EN010125: Application by RWE Renewables UK Dogger Bank South (West) Limited and RWE Renewables UK Dogger Bank South (East) Limited for the Dogger Bank South Offshore Wind Farms Project

The Examining Authority's further written questions and requests for further information

Issued on Tuesday 13 May 2025

Figure: 2-2	Drawing No: PB2340-MAR-OF-ZZ-DR-Z-0013	
Co-ordinate system: WGS 1984 UTM Zone 31N	Page Size: A3	Scale: 1:950,000
Project: Dogger Bank South Offshore Wind Farms	Report: Heat Mapping Report: Atlantic Herring and Sandeel

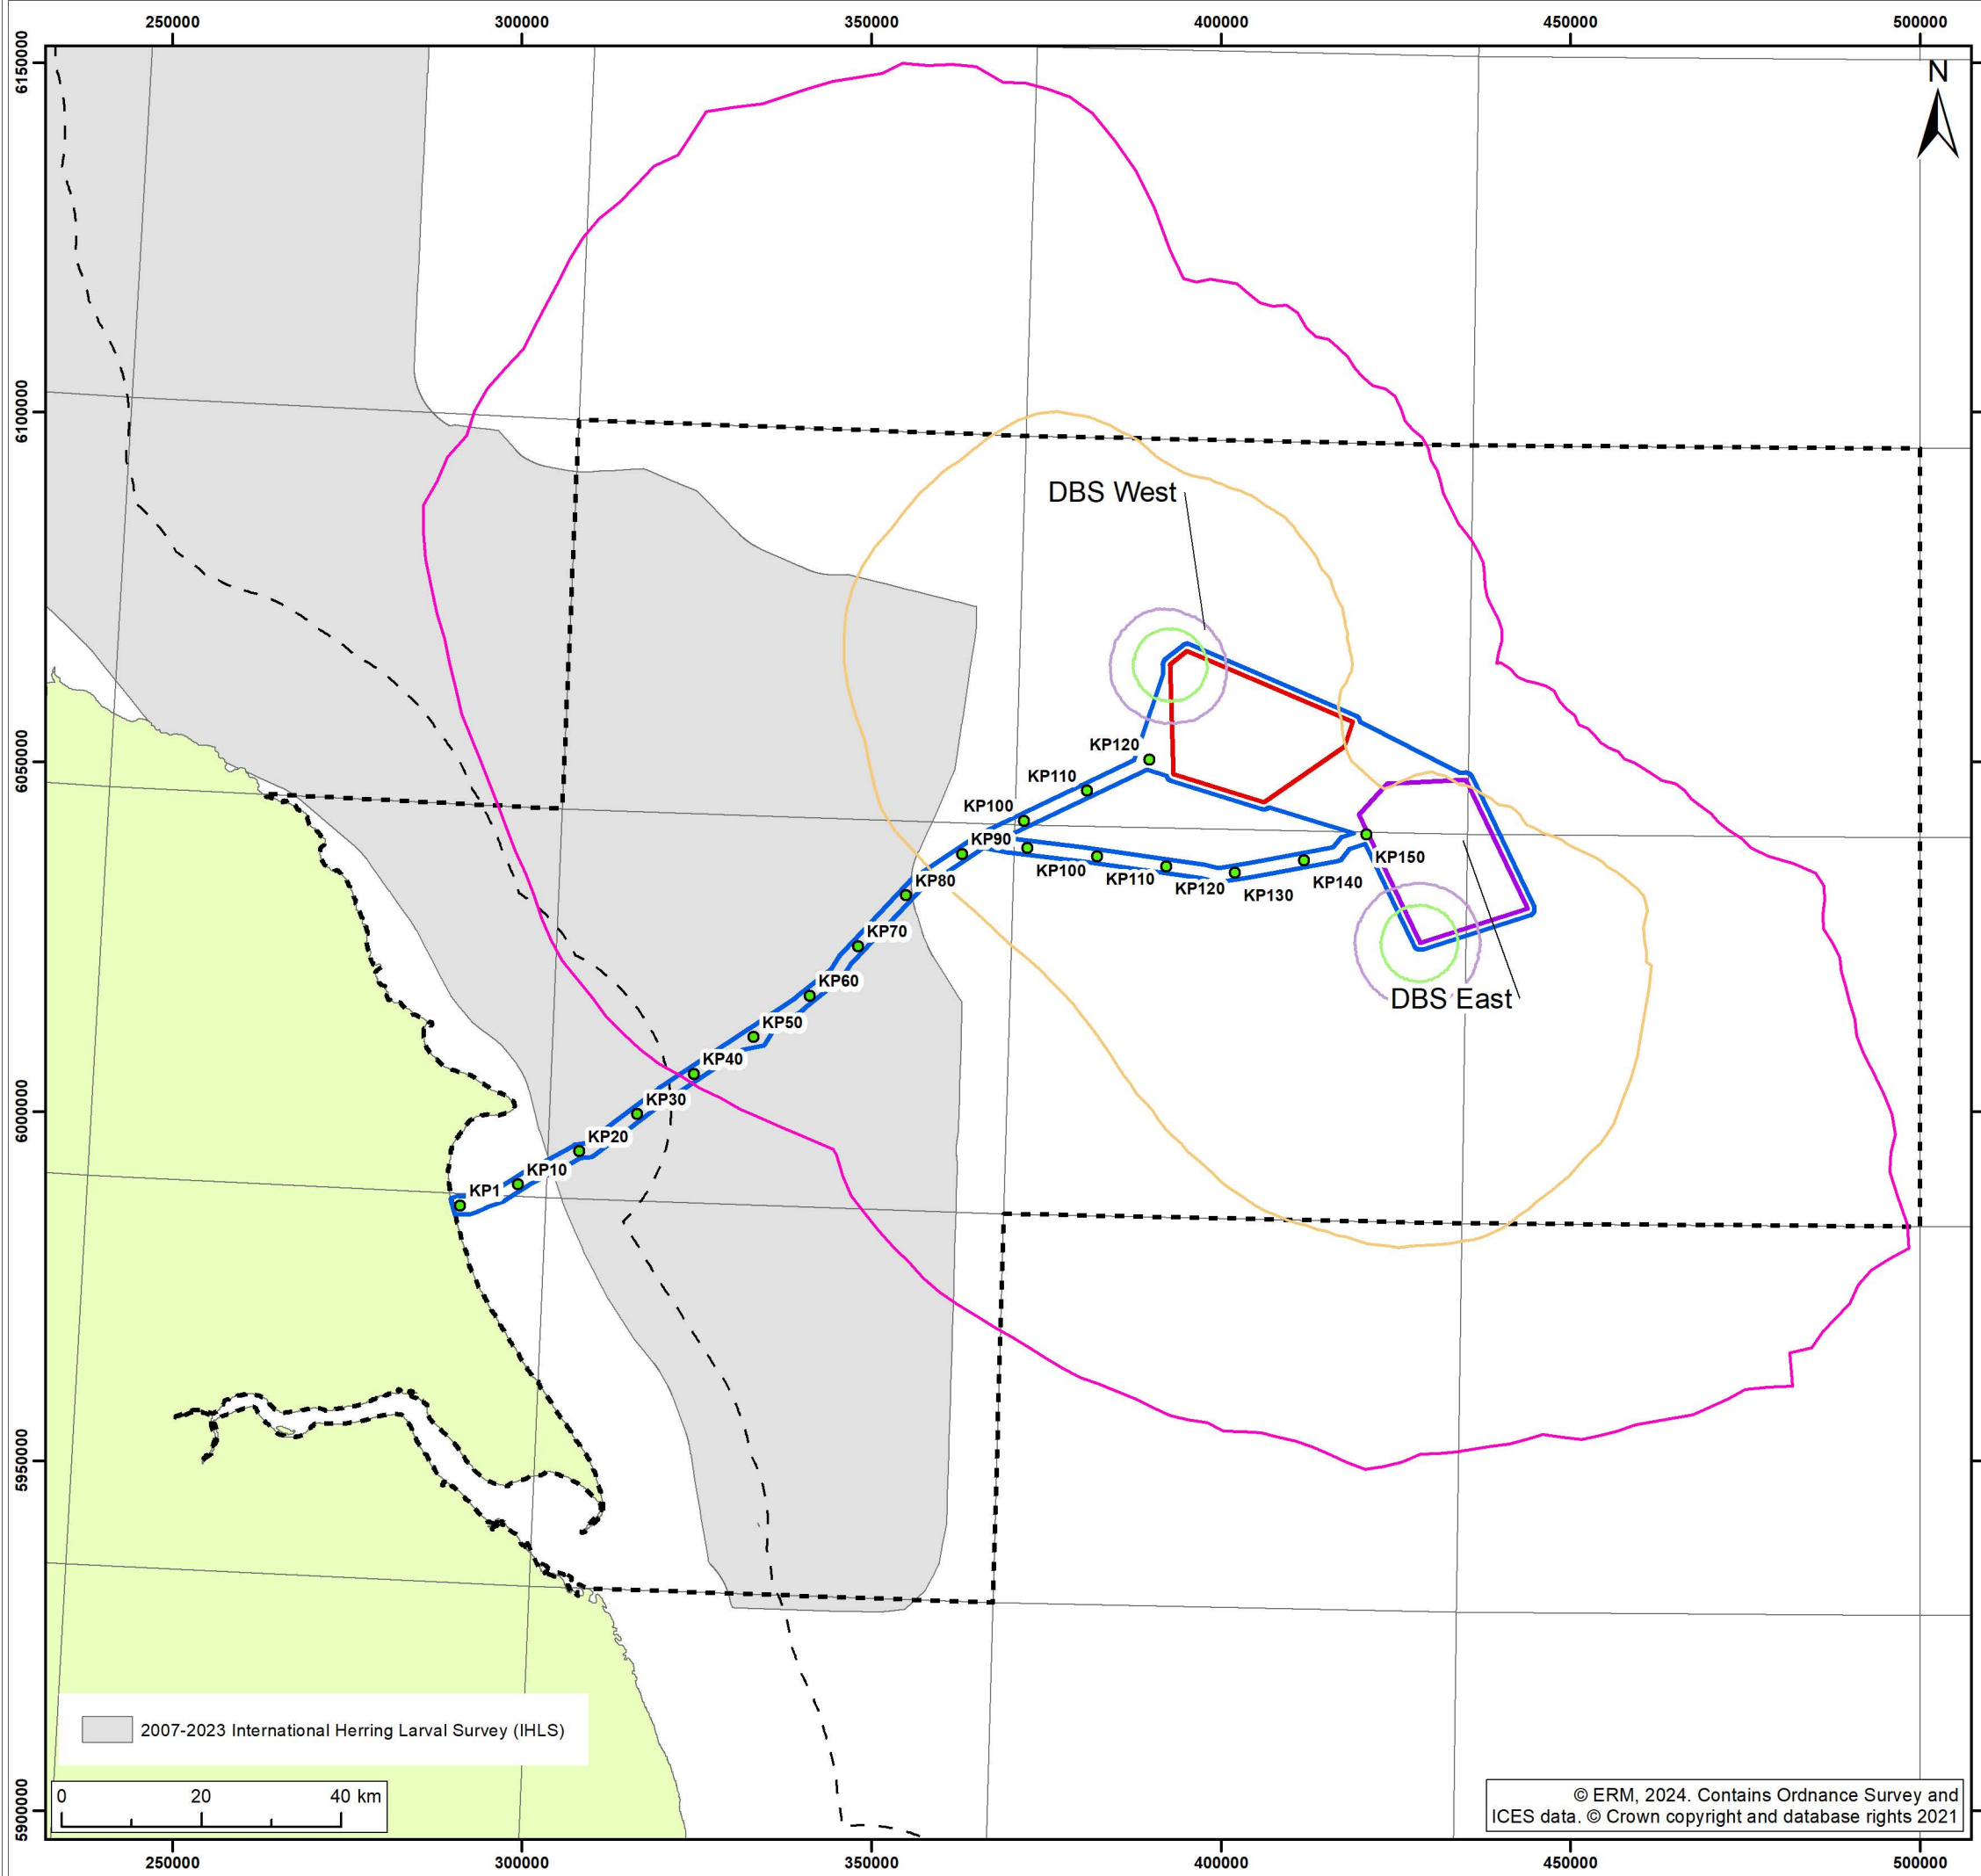
ExQ2	Question to:	Question
		g) 'applicants should have regard to duties in relation to Good Environmental Status (GES) of marine waters under the UK Marine Strategy and MPA target (including any interim target) in England, set under the Environment Act 2021'. NPS EN-3 paragraph 2.8.109
FSE.2.3	The applicants	National Policy Statement (NPS) EN-3 in relation to fish and shellfish The ExA notes that section 10.4 of ES Chapter 10 [APP-091] gives incorrect paragraph numbers for many of the quoted paragraphs in NPS EN-3. For example, paragraphs 2.8.138 to 2.8.141 should be 2.8.148 to 2.8.151. Can you review and correct all references to the NPS as necessary?
FSE.2.4	The applicants The MMO	Atlantic herring heat map In the applicants' response to action point 16 from ISH5 [REP4-096] they suggest that Figure 2-2 [AS-105] showing extents of preferred and marginal potential spawning habitats should be used in preference to Figure 2-1 [AS-105] displaying potential spawning habitat heat map for Atlantic herring. In AS-105 the applicants explain that the information in Figure 2-2 is one of the inputs to the overall heat map in Figure 2-1. The applicants: Explain why you believe the other inputs use to create to the overall Atlantic herring heat map illustrating herring spawning potential in Figure 2-1 should be disregarded in preference of only considering the preferred spawning habitats for Atlantic herring in Figure 2-2? The MMO: Please provide the MMO's opinion on the applicants' use and comparison of Figure 1-2 and Figure 2-2 described above and their relevance to areas of medium and high potential herring spawning areas.
